CITY OF ALBUQUERQUE

RE: **Winrock Town Center – Phase B (J19D058E)**
Grading Plan, Engineer's Stamp Date: 3-11-2016

C101

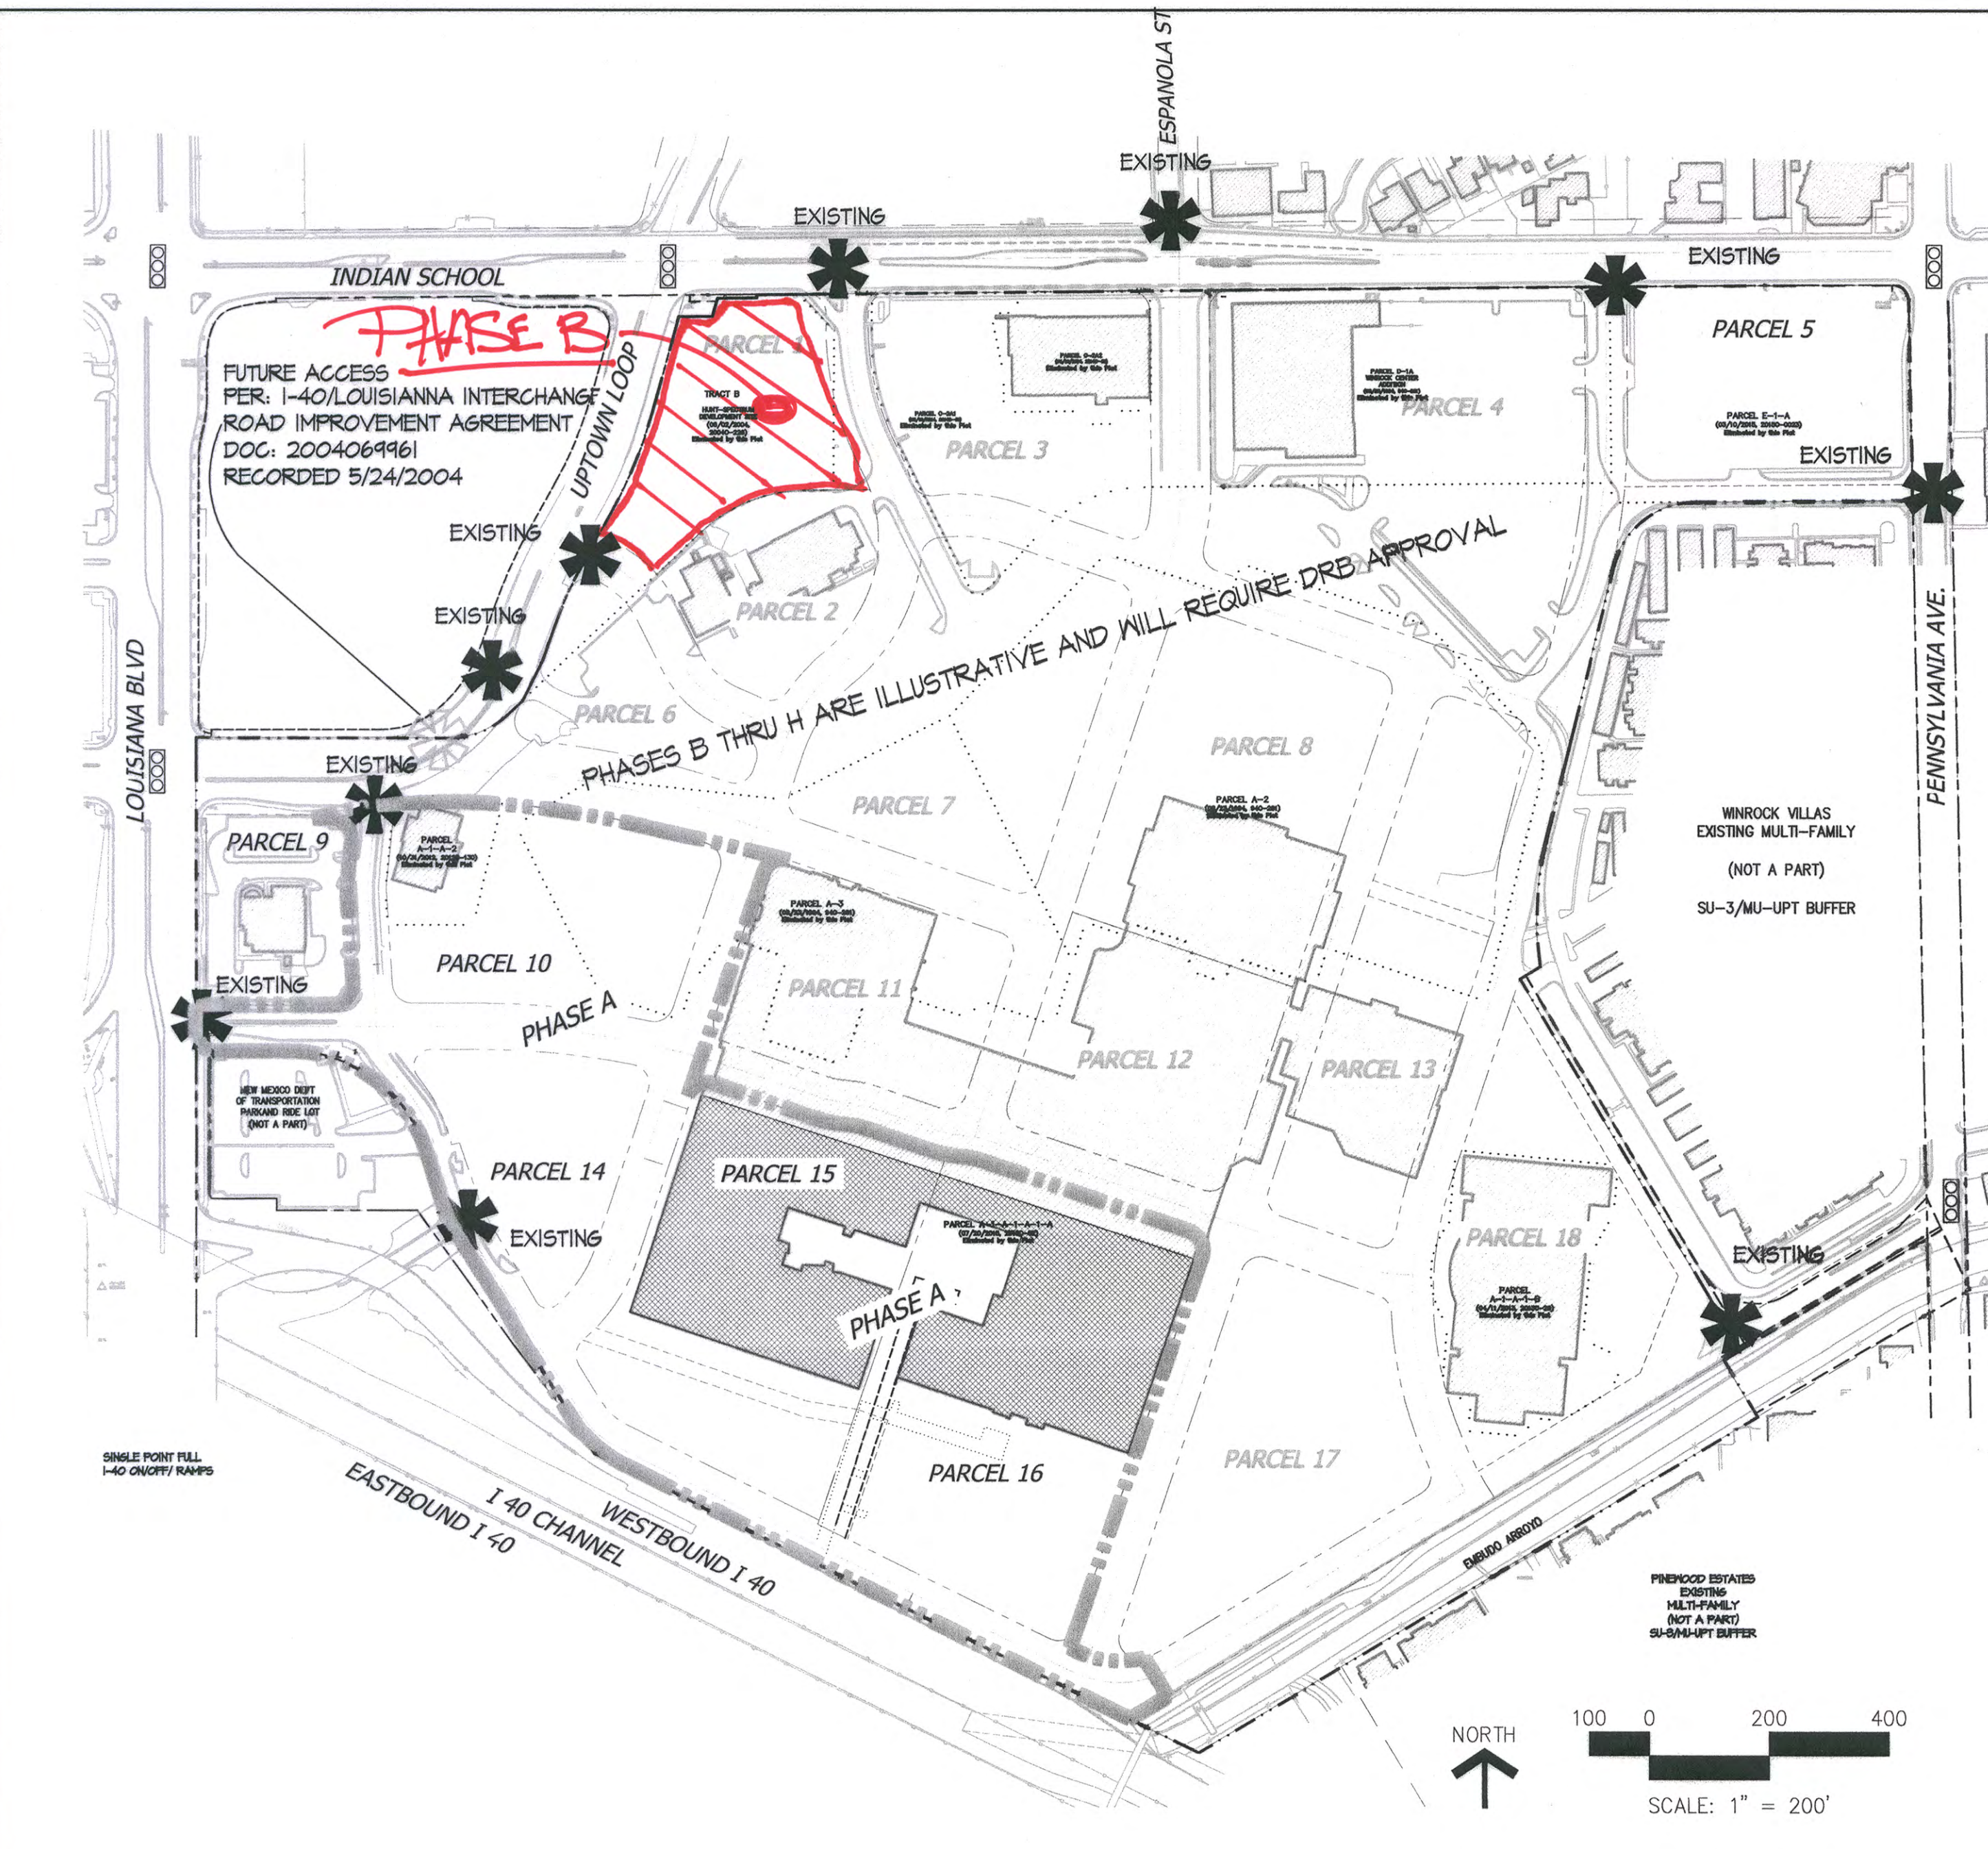
- Show the slope of all storm drain pipe on the plan
- Show the Invert in and invert out on all inlets
